MEMORANDUM

SUBJECT: SF-19-018 – Branding Iron at Sterling Ranch Filing No. 2
Response to Comments Letter

SPRAGUE WAY CDS STA 0+00.00 TO STA 2+85.83

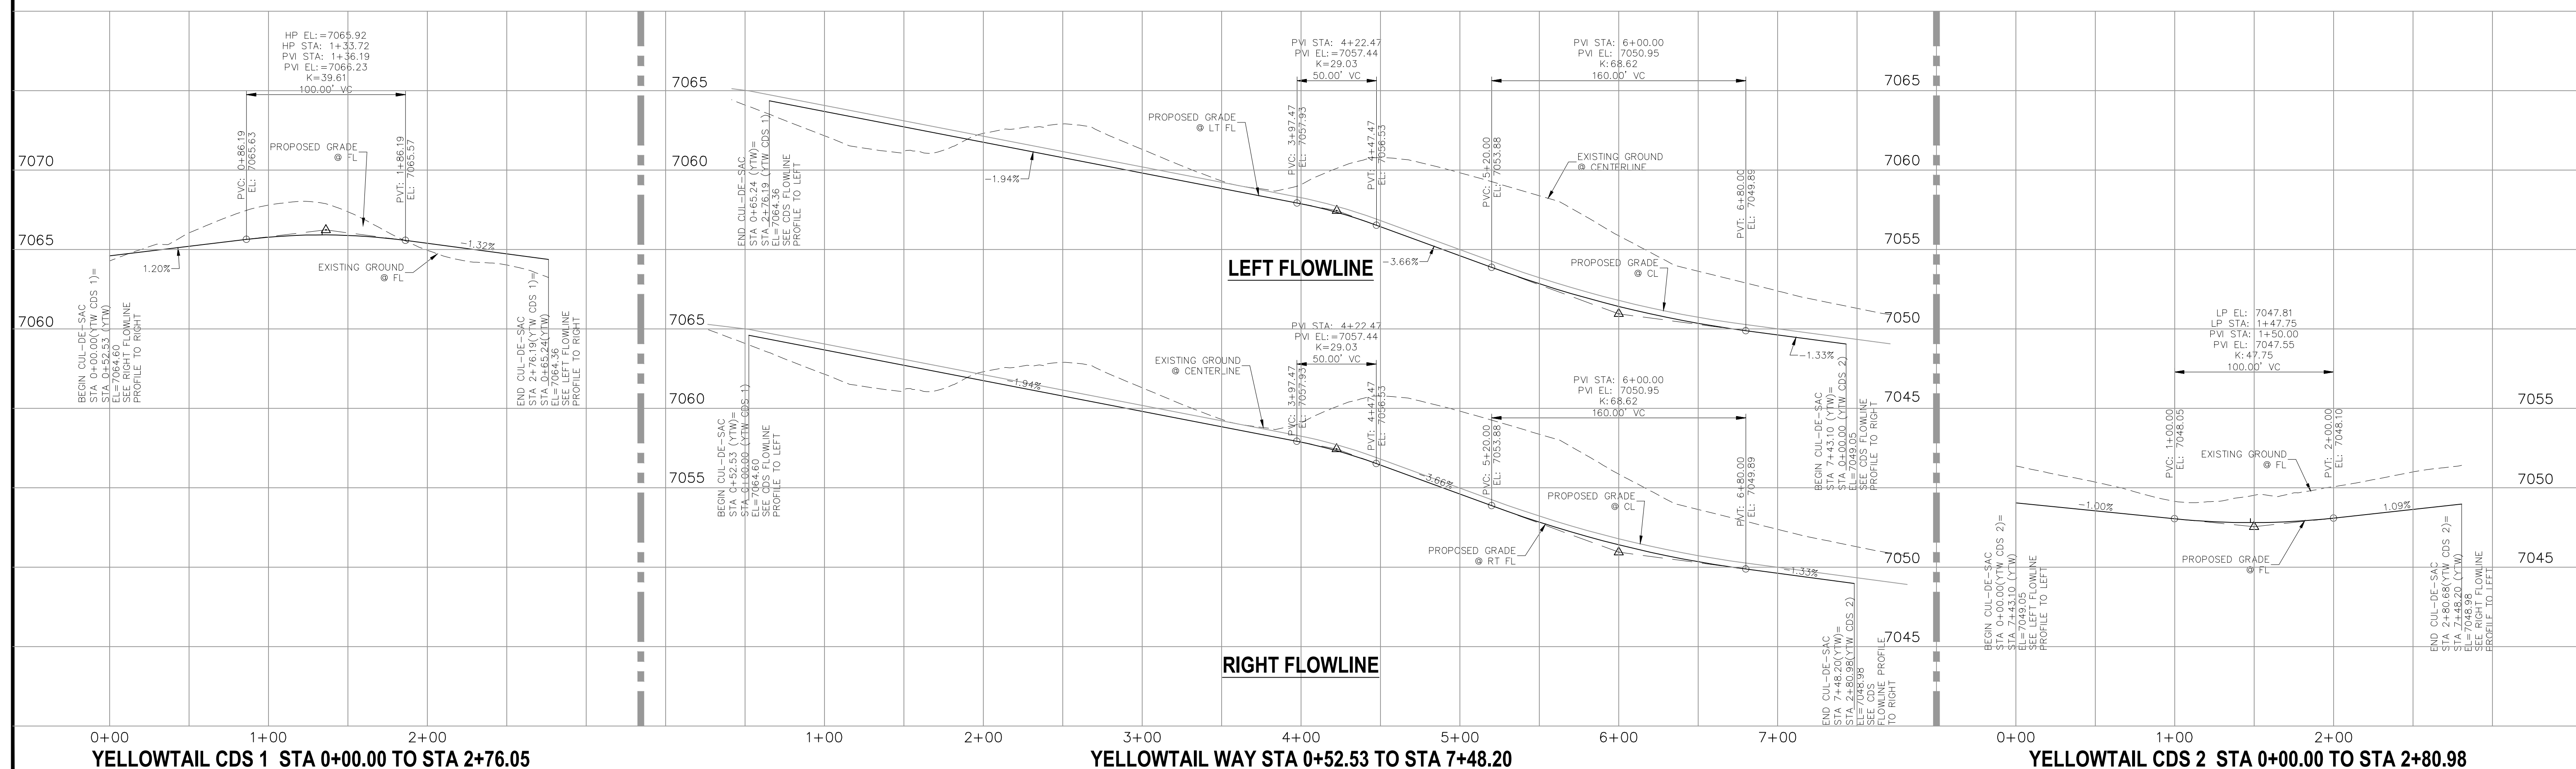
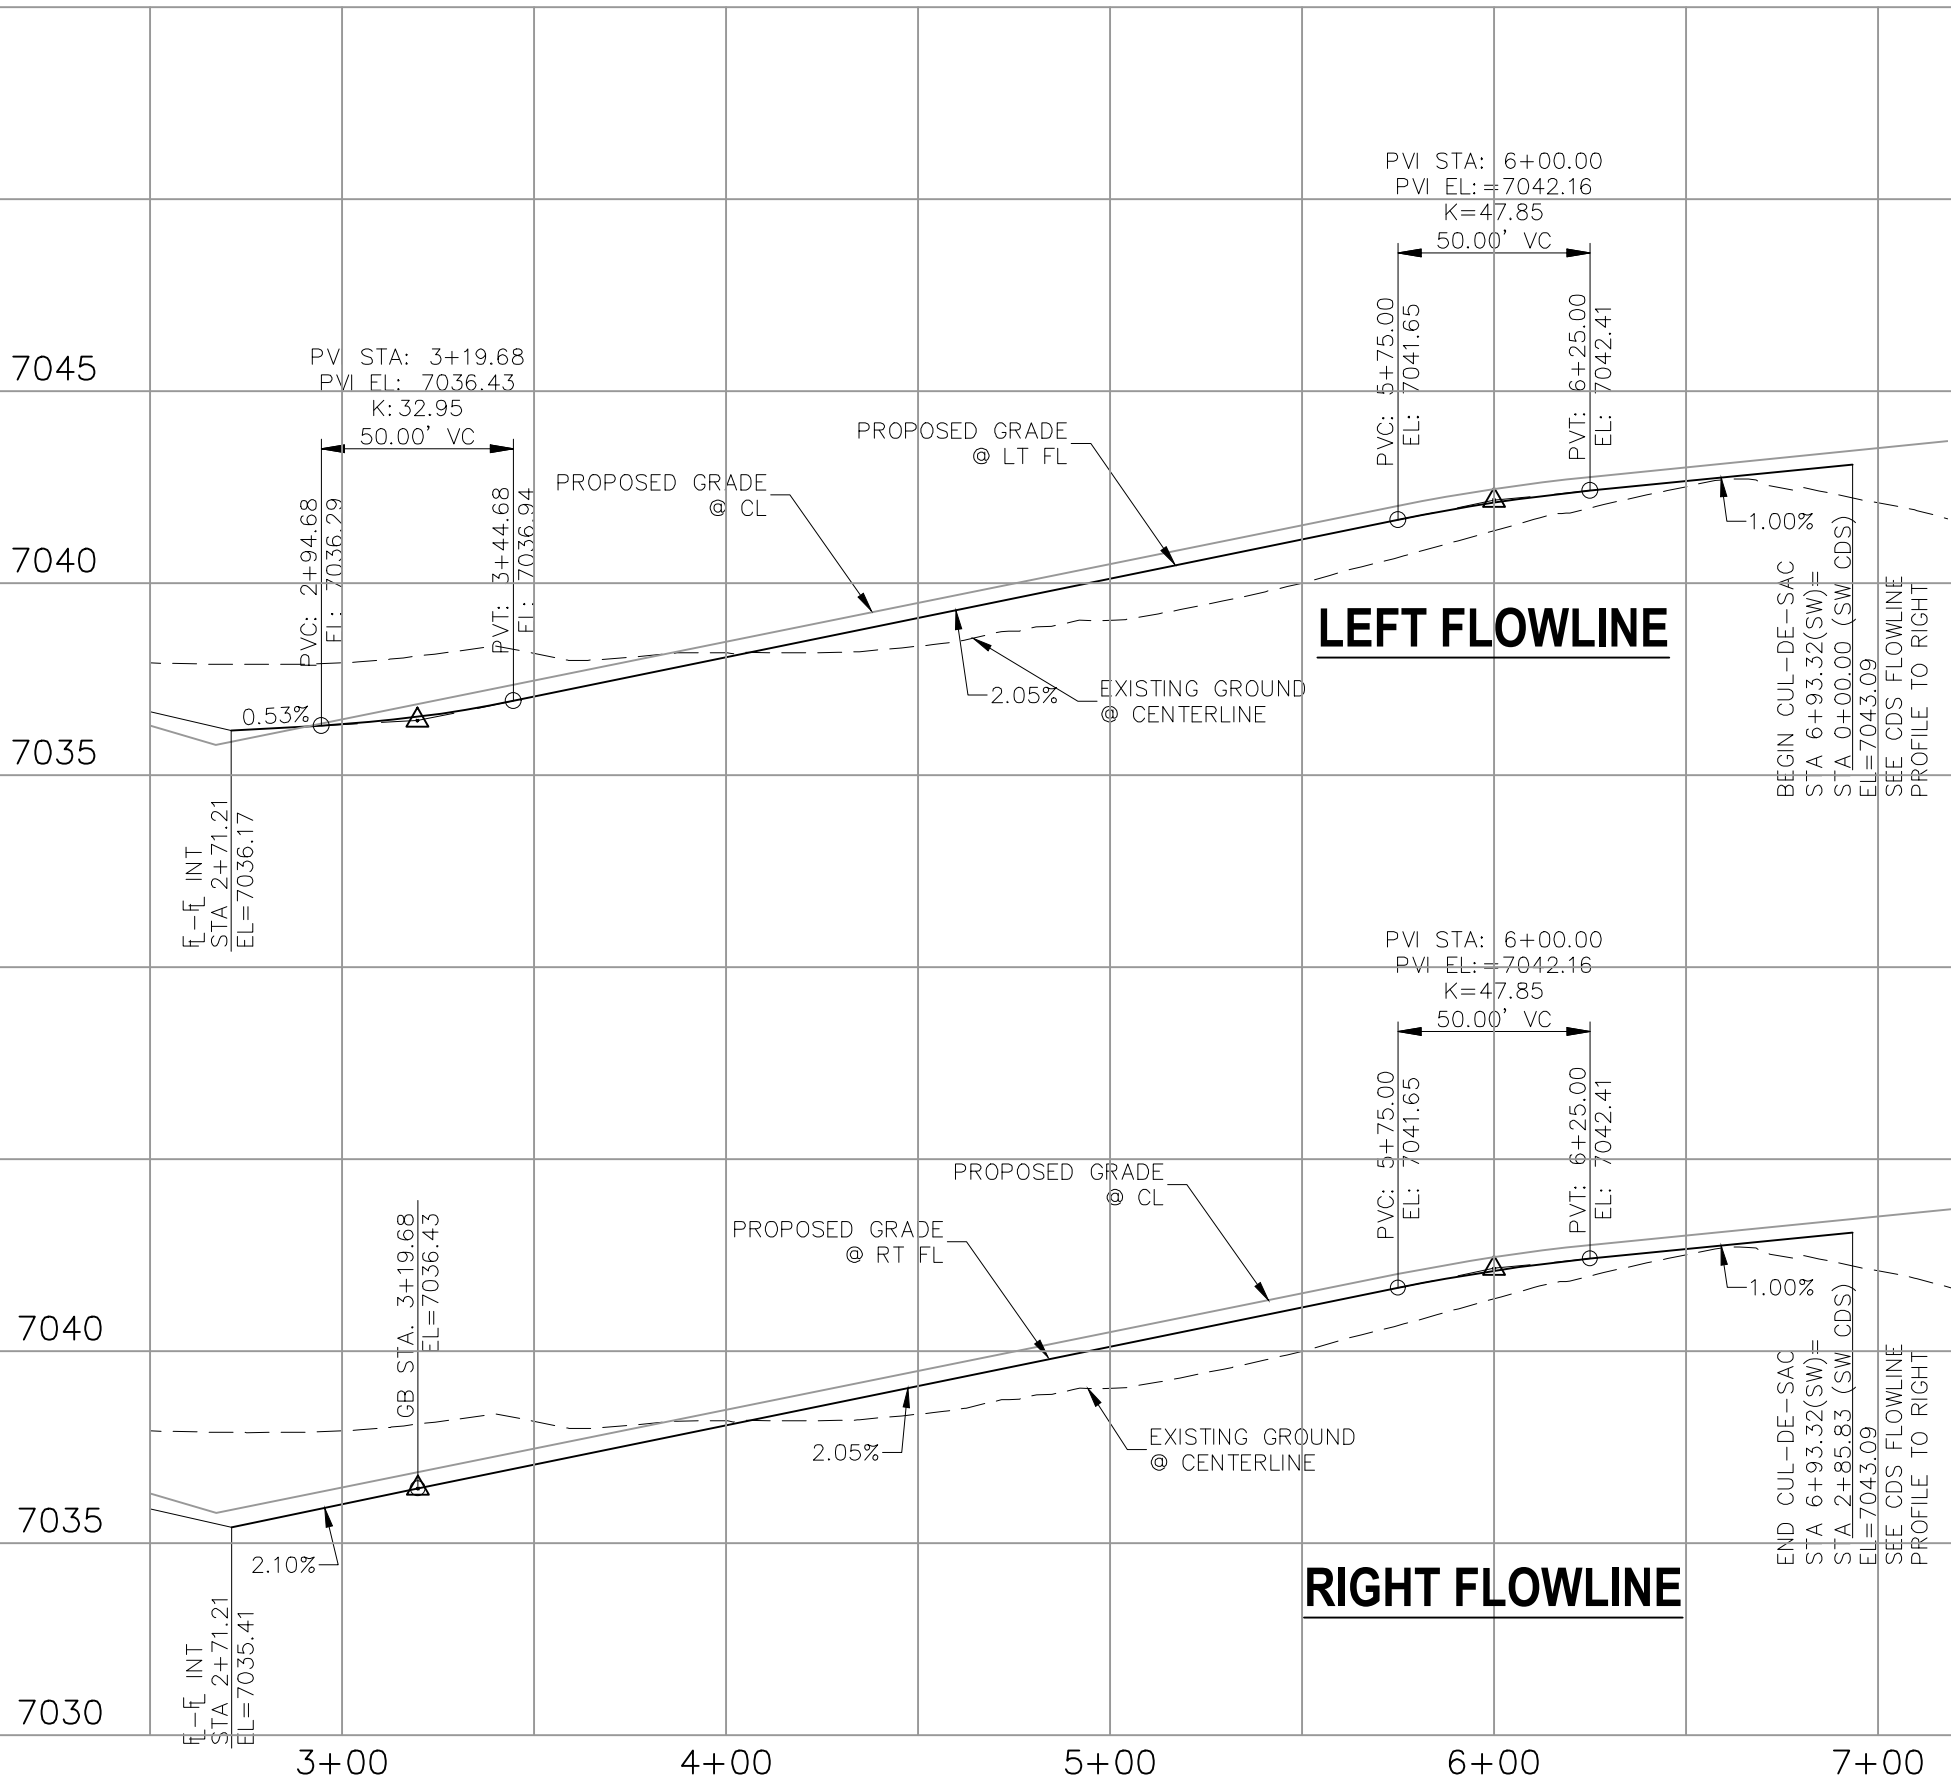
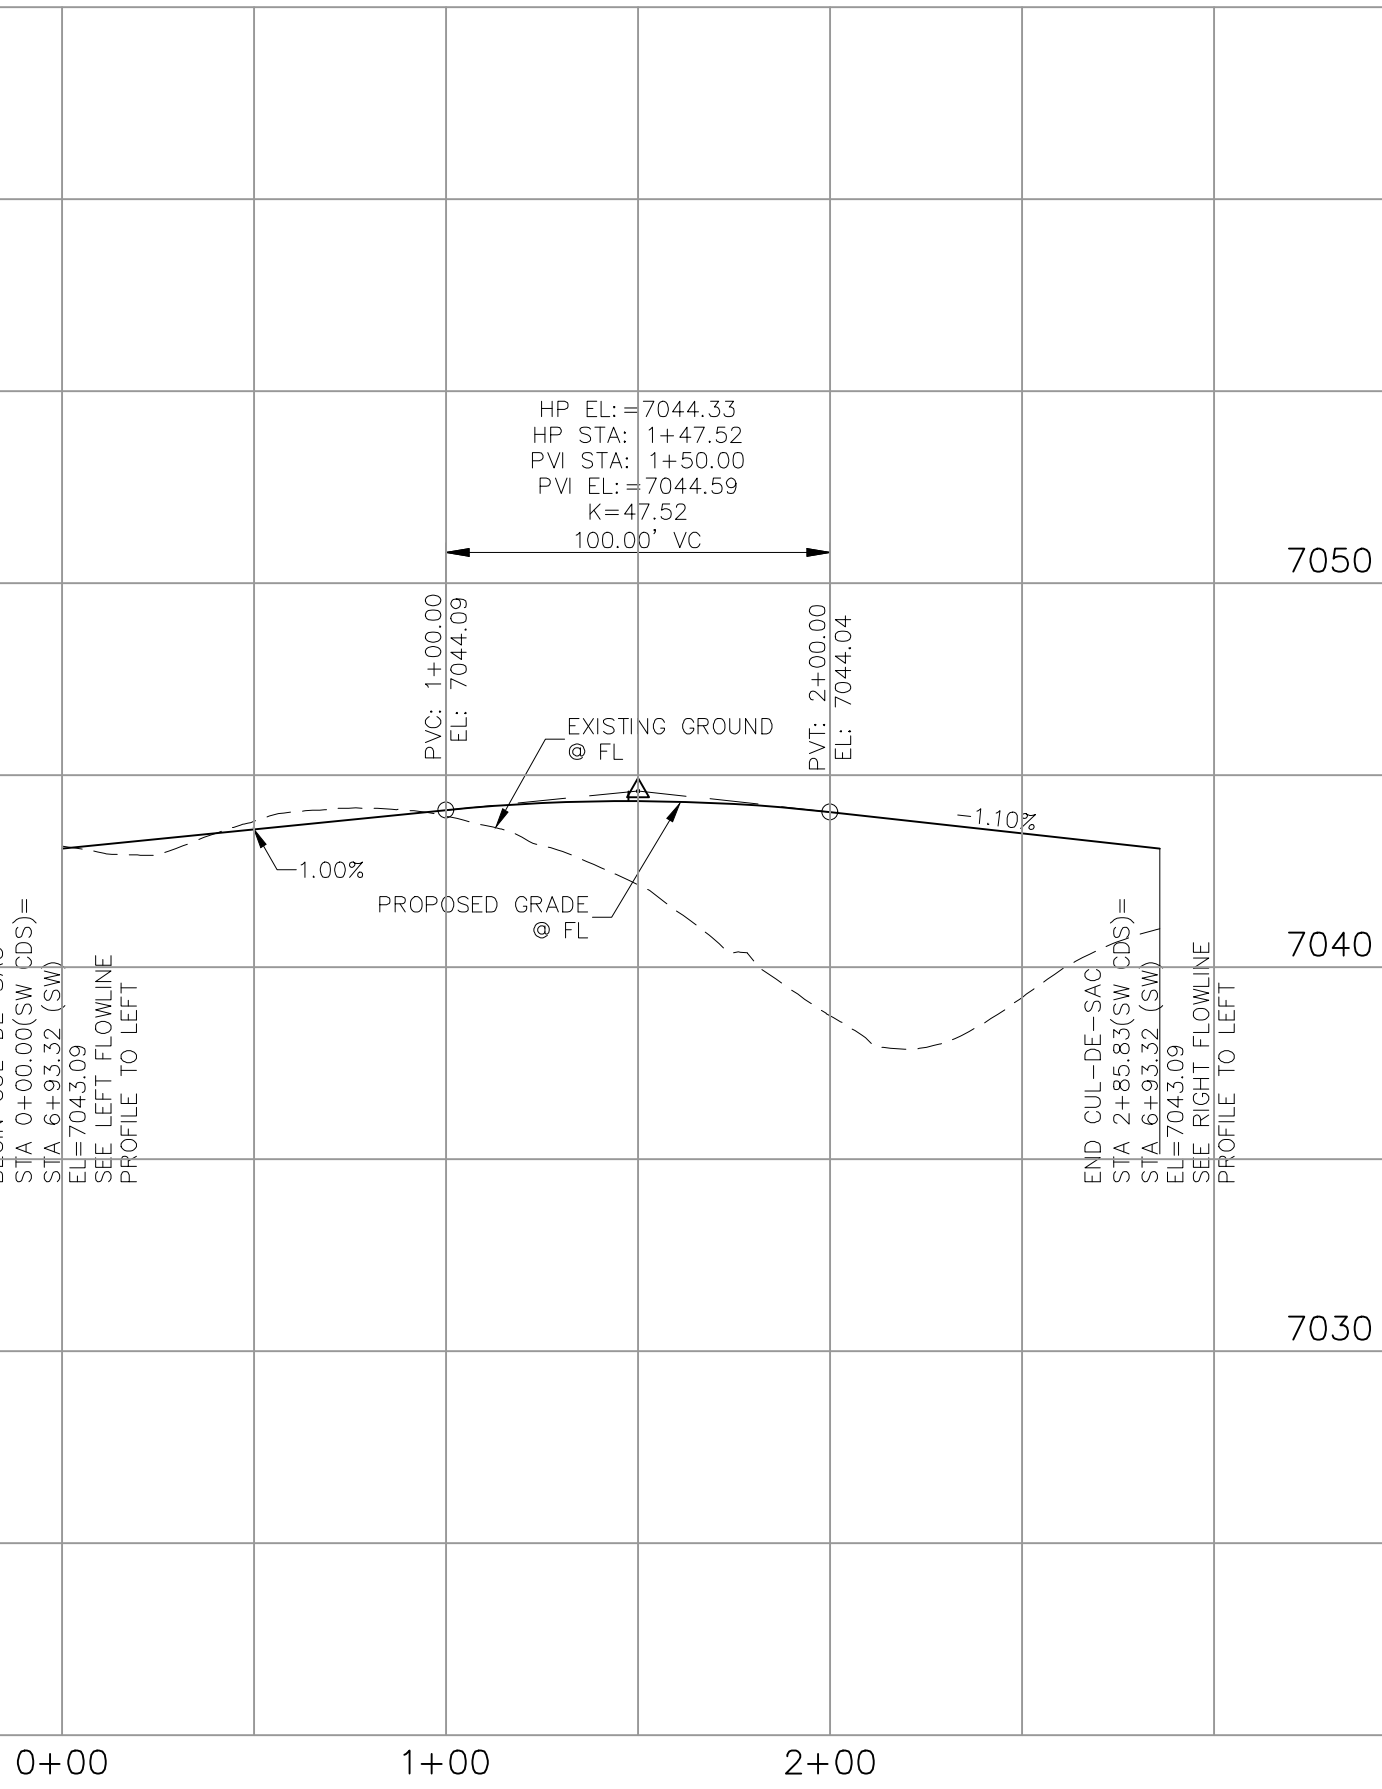
1. Resolved.
2. Resolved.
3. Verify that geologic hazard and soils report recommendations have been addressed appropriately for this specific subdivision filing. Specifically address construction requirements for the east end of Sprague Way. **To be addressed in pavement design report. Noted**
